26 June 2013

Our Ref: 130626PDADOPI&COS

**SICEEP – The Haymarket Stage 1 Stage Significant Development Application (SSD 5878 – 2013)
– Hyder Consulting response to stakeholder comments, recommendations and key issues.**

DRAWING TITLE				
PMF PROPOSED DEVELOPMENT FLOOD DEPTH AND LEVEL CONTOURS INCLUDING POTENTIAL CLIMATE CHANGE				
STATUS				
PRELIMINARY ONLY				
SCALE @ A1	DRAWN	DESIGNED	REVIEWED	APPROVED
1:1500	RD	CM	BC	JH
PROJECT NUMBER	DRAWING NUMBER		REV	
AA004399	WP-FL-0134		01

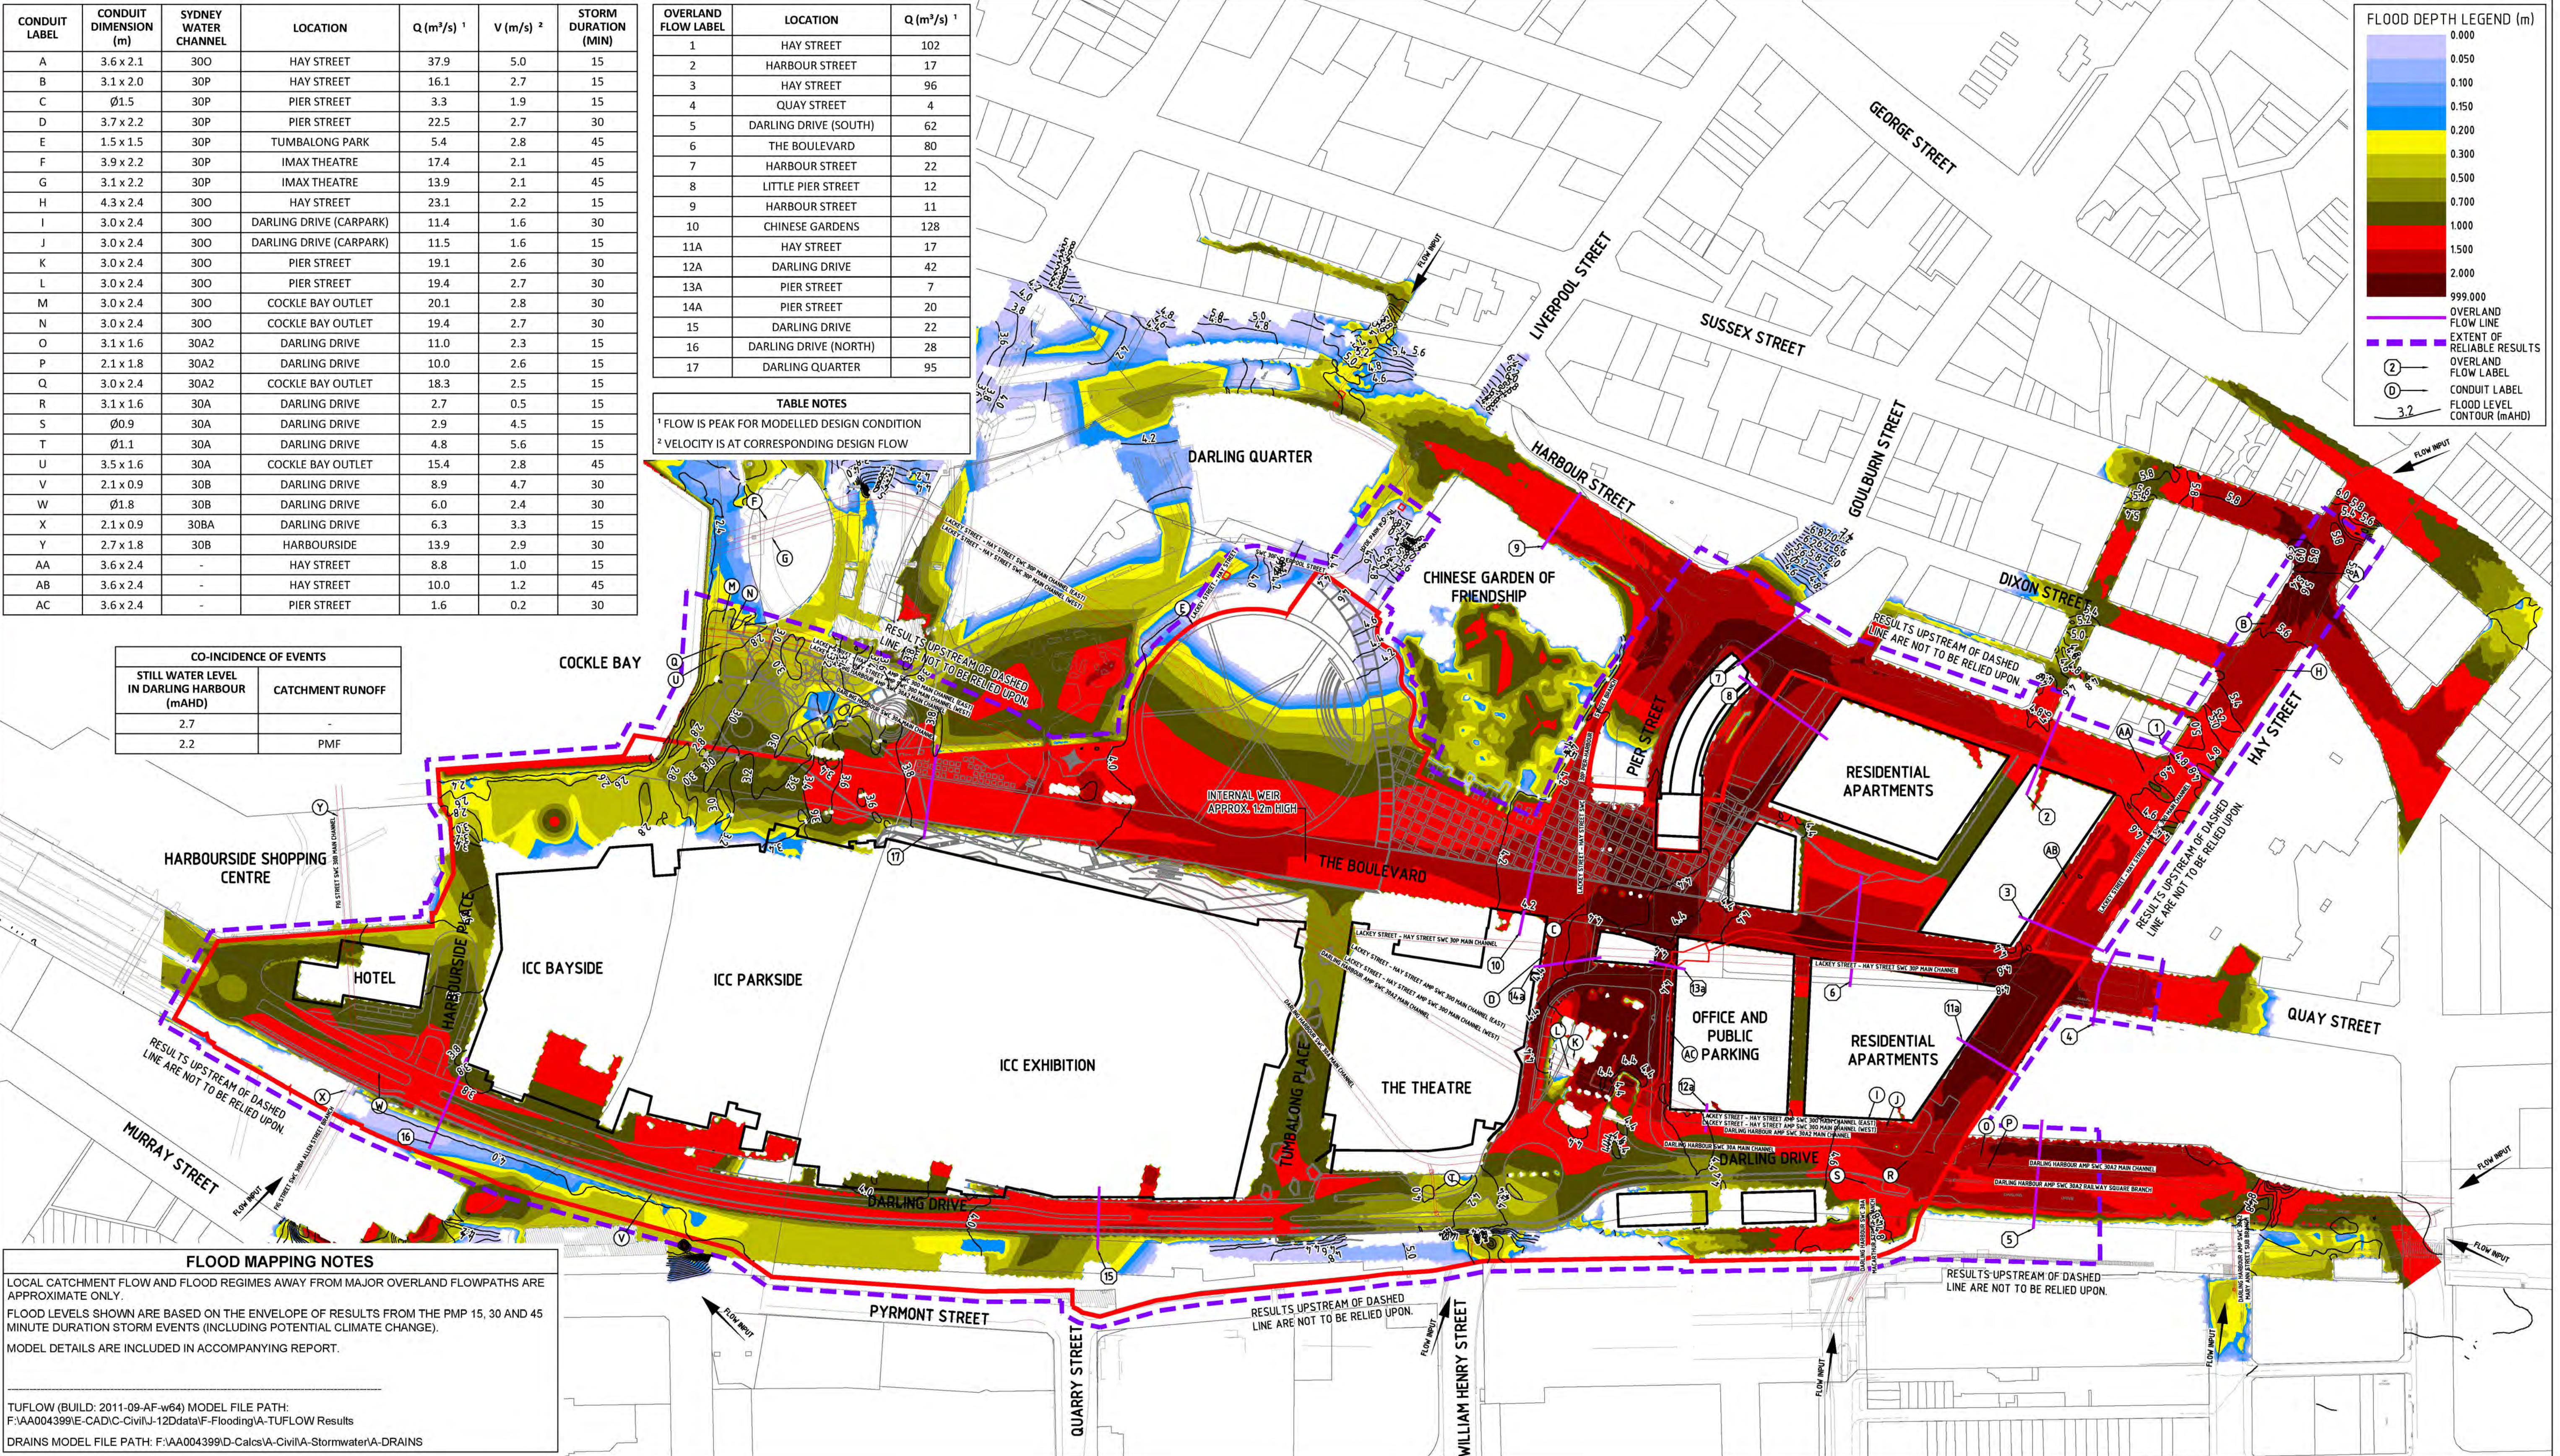
DOPI Key Issue (Stormwater)	Hyder Response
	design of WSUD treatment trains which achieve industry accepted / best practice water quality targets.
<p>29. With reference to the TUFLOW Model at Appendix C, clarification is required of the following:</p> <p>a) how potential climate change applied to the PMF event and whether this involved applying sea level rise only;</p> <p>b) it is unclear from the colour coding for localised flood Impacts what the maximum impact is at the northern end of the Boulevard (i.e. is it in the order of 0.5m or considerably higher). Identify the cause of the & flux and provide details as to whether is it possible to eliminate/mitigate at a later stage of the design; and</p> <p>c) what technique has been used to map the provisional hydraulic hazard (i.e. how were the hazard categories defined in Figure L2 of the Floodplain Development Manual translated to mapped outputs).</p>	<p>a) Hyder has applied sea level rise only to the PMF modelling.</p> <p>b) The afflux in this area has been investigated in the modelling and is suggested to be due to a change in the local drainage systems and catchment break-up. It is expected that with further detail this afflux can be mitigated/eliminated.</p> <p>c) The provisional hydraulic hazard mapping has been an output from TUFLOW (similar to flood depths and velocities) with the _Z1.dat function. The results (based on the maximum D x V) produce a number, of 1, 2 or 3, representing Low Hazard, Intermediate Hazard or High Hazard, respectively. These numbers have then been mapped based on the grid output.</p>
